Planning Officer: Mr S Davis

Planning Application Ref: AL/64/20/PL

Location: Springfield, Hook Lane, Aldingbourne, PO20 3TE

Description of works: Demolition of the existing dwelling & construction of 2 no. 2-bed. 3 no. 3-bed, 4 no. 4-bed houses including access, landscaping & associated works (resubmission following AL/27/20/PL).

Drainage Strategy				Draining The
Engineering Details				
Drawn	Checked	Scales	Paper Size	Date
JN		1:250	A1	08.19
Job No.				Revision
KNC/1932	602-01			C

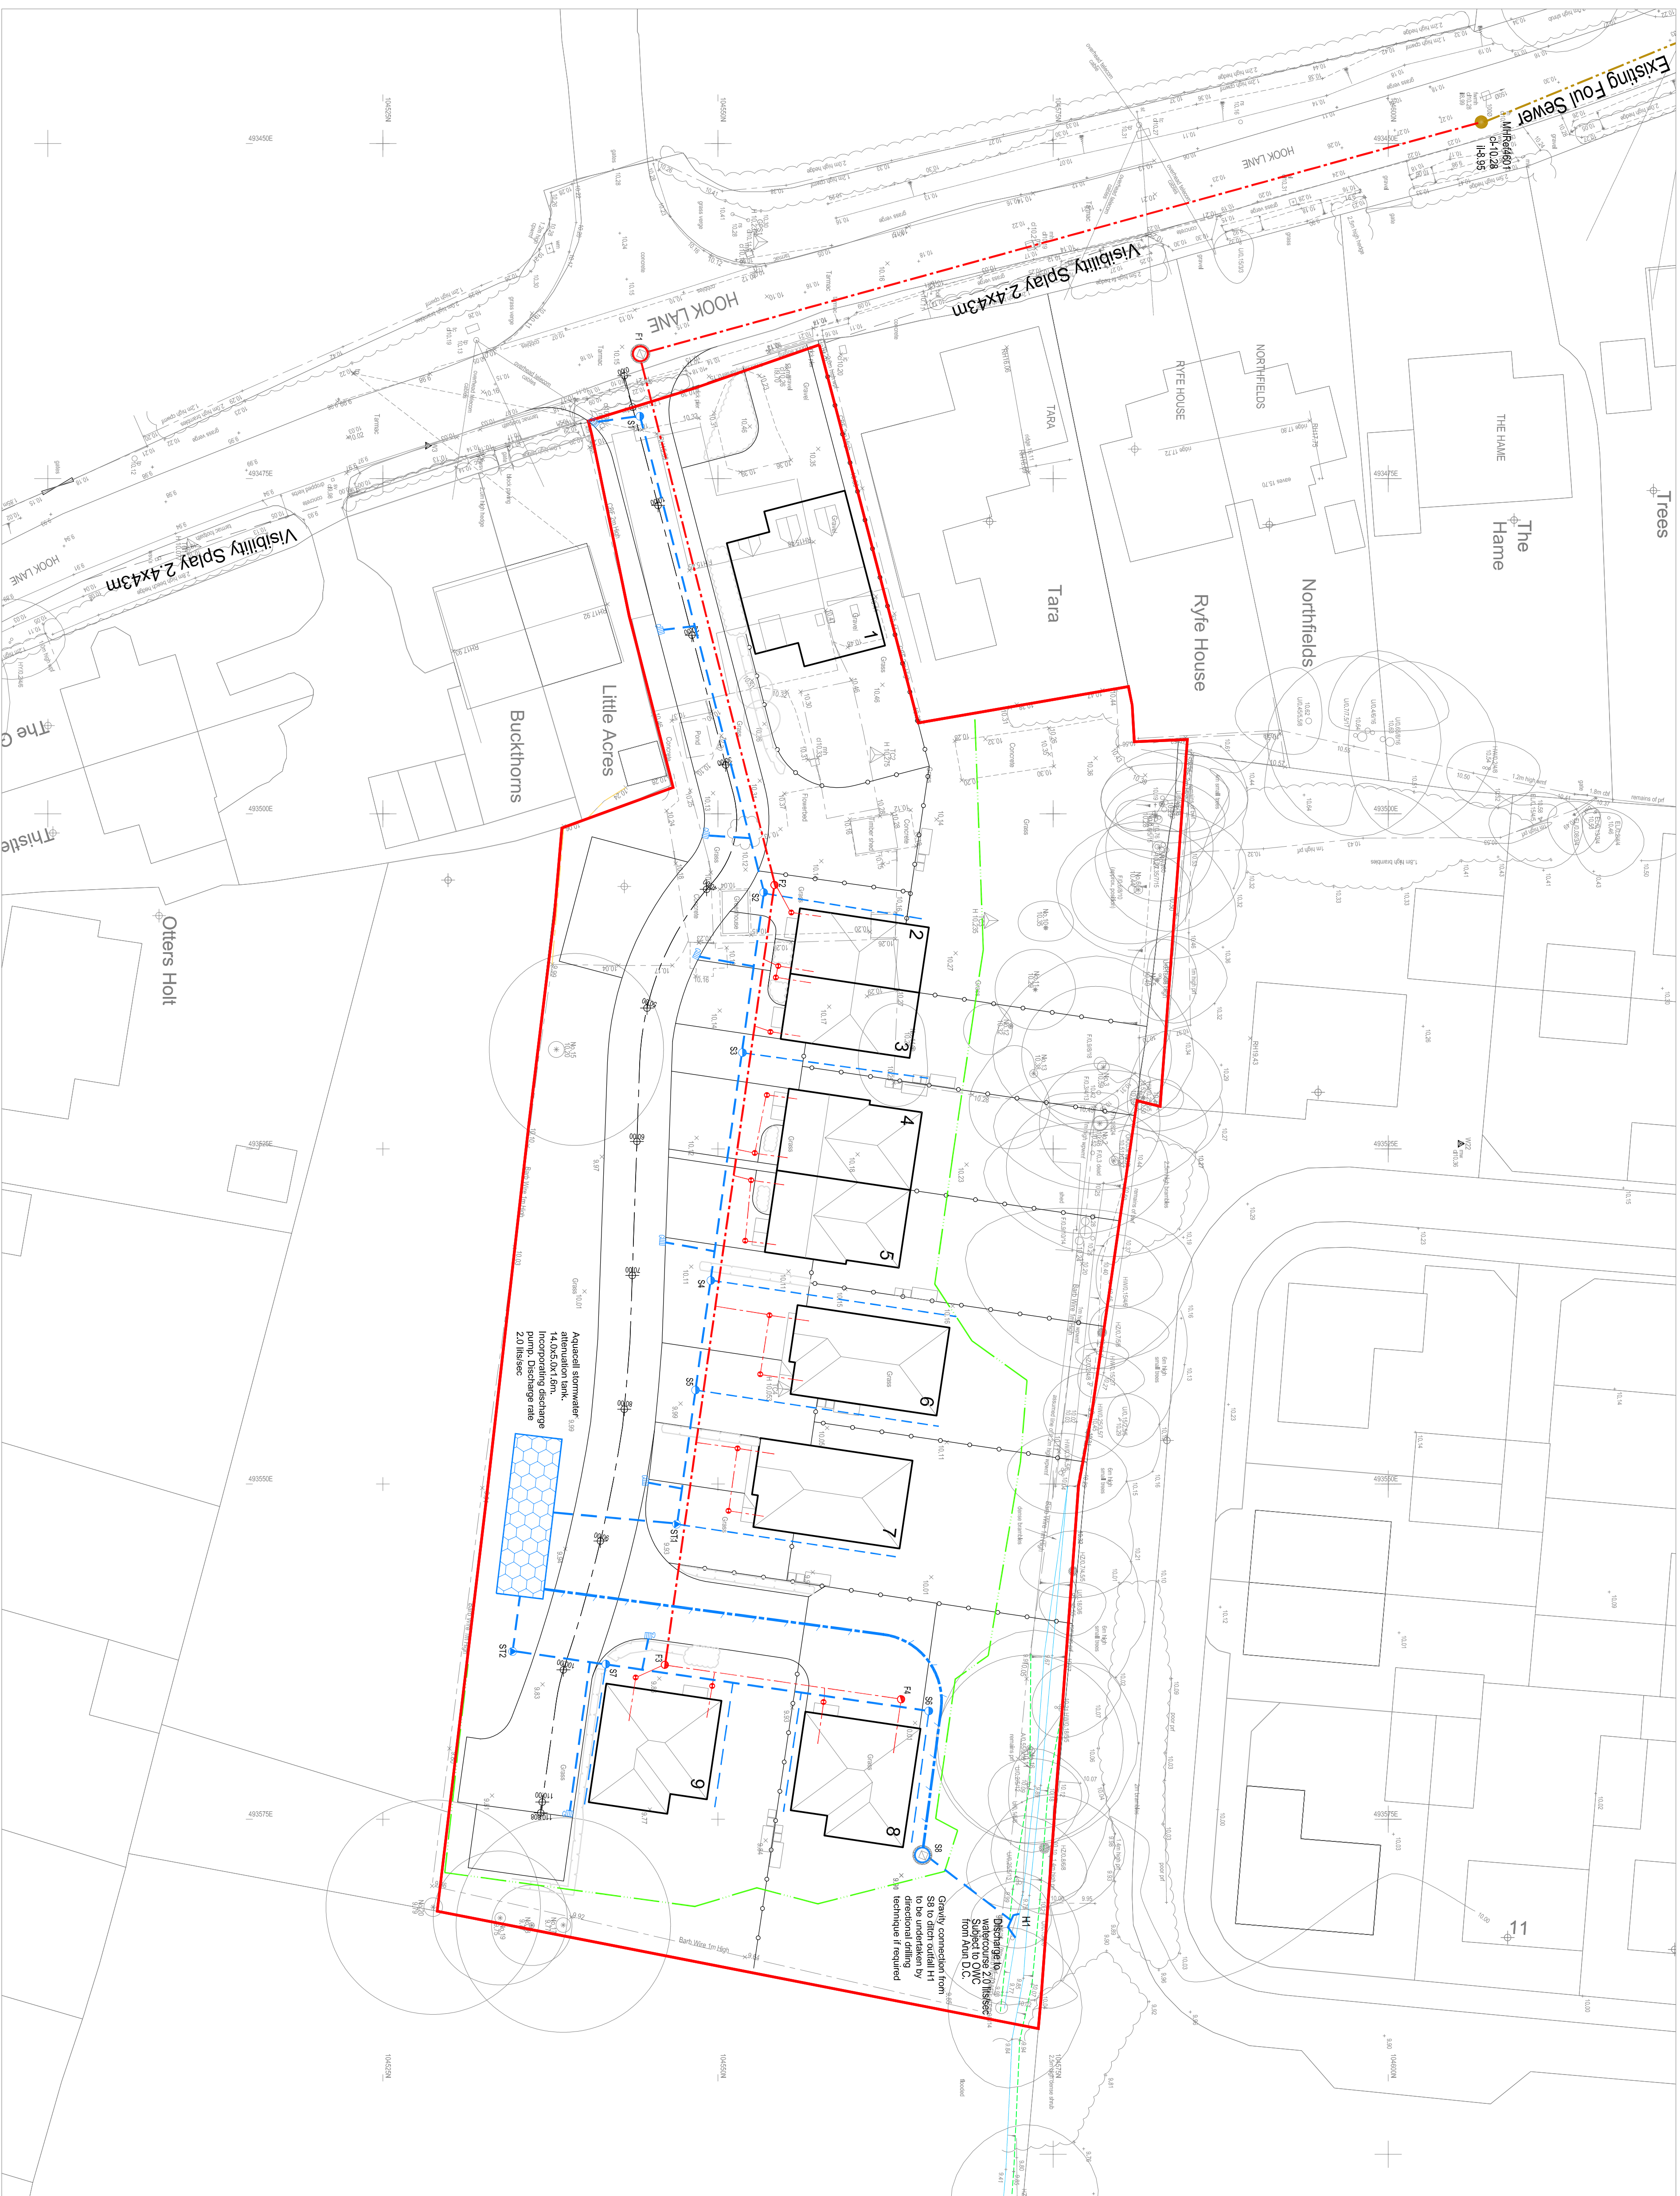
- The Engineering Details Drainage Strategy for the site as illustrated (dwg. no. 602-01, Rev C) is broadly respectful of retained trees and their growth potential, with the obvious exception being chosen route of surface water discharge to the north boundary watercourse and construction of headwall – both within the RPA of retained (off-site?) mature Cypress T21. Directional drilling technique is proposed '*if required*'. I say it is necessary unless exploratory excavation findings permit standard trenching. All that to be set out in the required Arboricultural (Impact Assessment &) Method Statement. Might it not be easier to take a more northerly route from manhole S8 and avoid significant tree's (T18 & T21) RPA altogether, subject to suitable ground levels (gravity connection)?

Drawing title
Tree Retention and Protection Plan
Domusea Developments Ltd

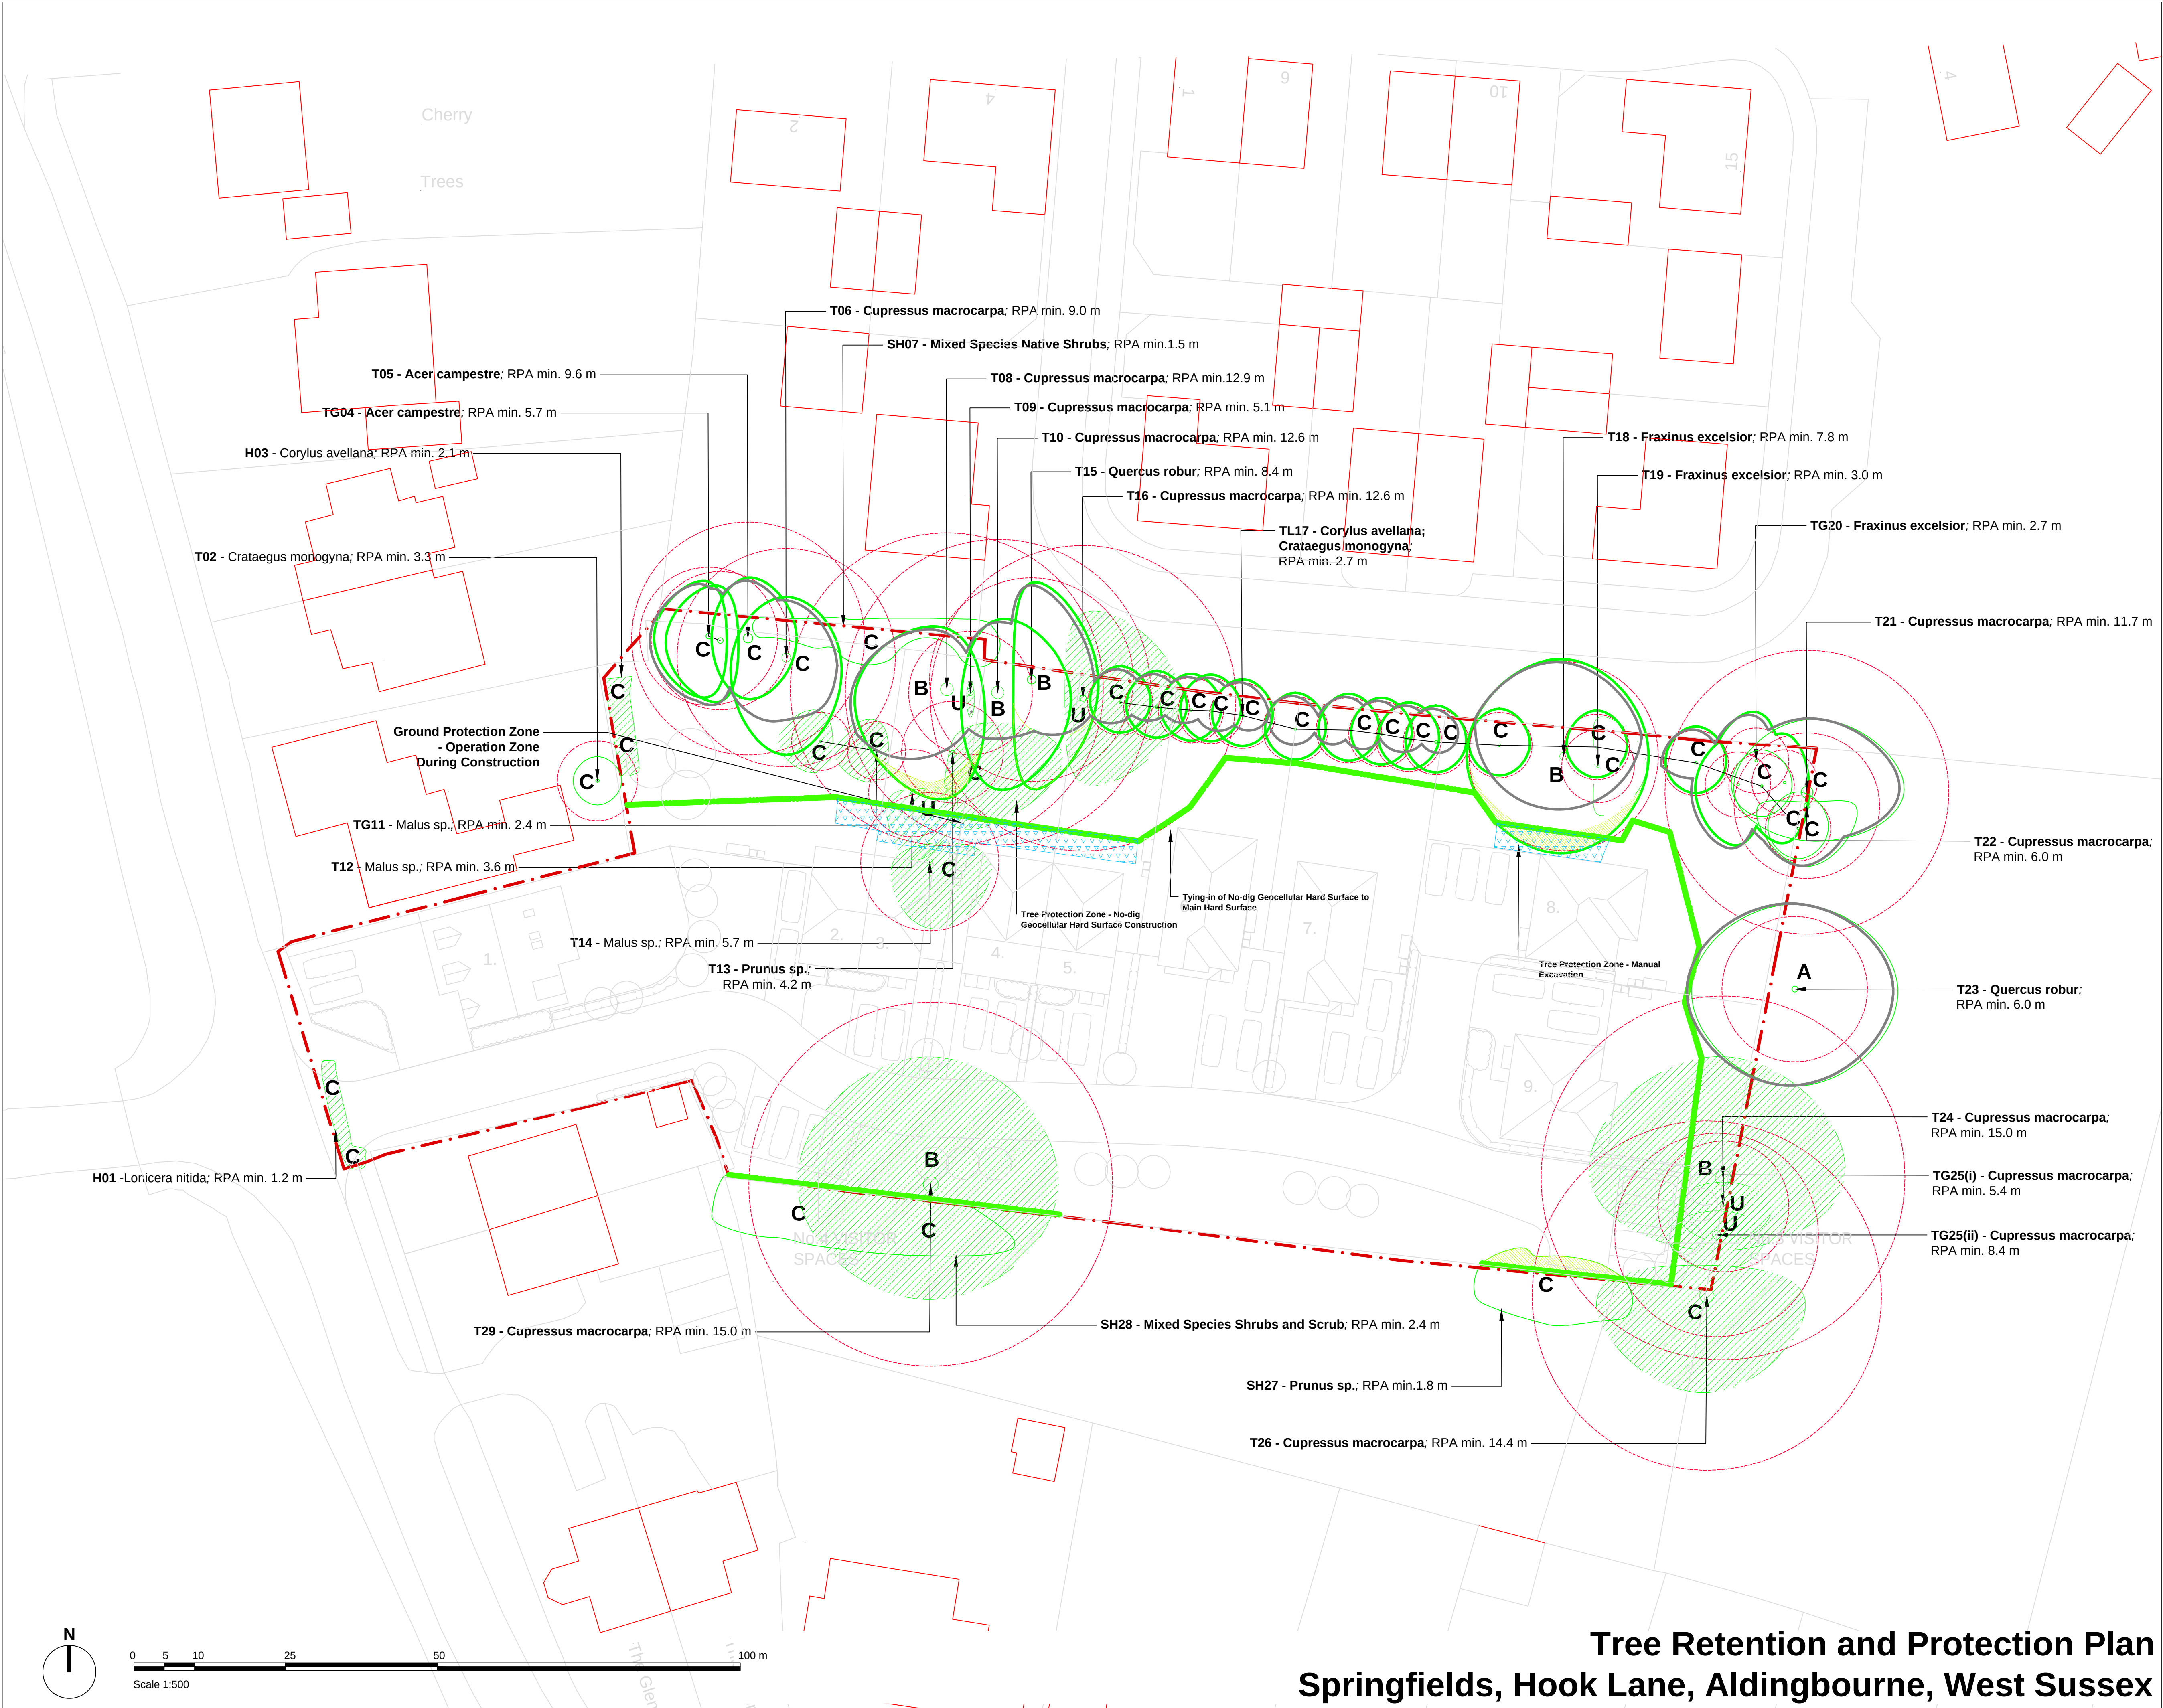
- I have considered this application by means of a desktop review, using the information and plans submitted as well as online resources.
- The applicants have employed **Lizard Landscape Design Ltd** to prepare a Tree Retention and Protection Plan for this project, but without a supporting Arboricultural Impact Assessment & Method Statement - a requirement of BS5837:2012. As such, were this application to now proceed, we will not have sufficient information to guarantee such trees would be adequately respected and protected.

- In broad terms, the proposal as it stands can be implemented by retaining the majority of large evergreen trees, that are of obvious landscape value. A number of these have also been identified as Category B trees, a rating I can comfortably support. It is therefore disappointing there is no attempt to retain T24 & T29 Cypress when they could be in harmony with the dwelling (plot 9) and access road, by selective branch shortening and if a 'No-dig' construction method was employed. That said, neither is suitable for a Tree Preservation Order and so we cannot prevent their removal, although I would expect to see adequate mitigation.

- The proposed removal of T24 & T29 is unfortunate. The important tree line along the north boundary is suitably accommodated and with far less intrusion into likely rooting zones.
- We need to see a detailed landscape plan inclusive of tree planting proposals to ensure adequate mitigation for the loss of so much high canopy.
- Drainage Strategy needs to be re-considered in part and must be approved in association with the overall layout, to ensure adequate safeguarding of retained trees.
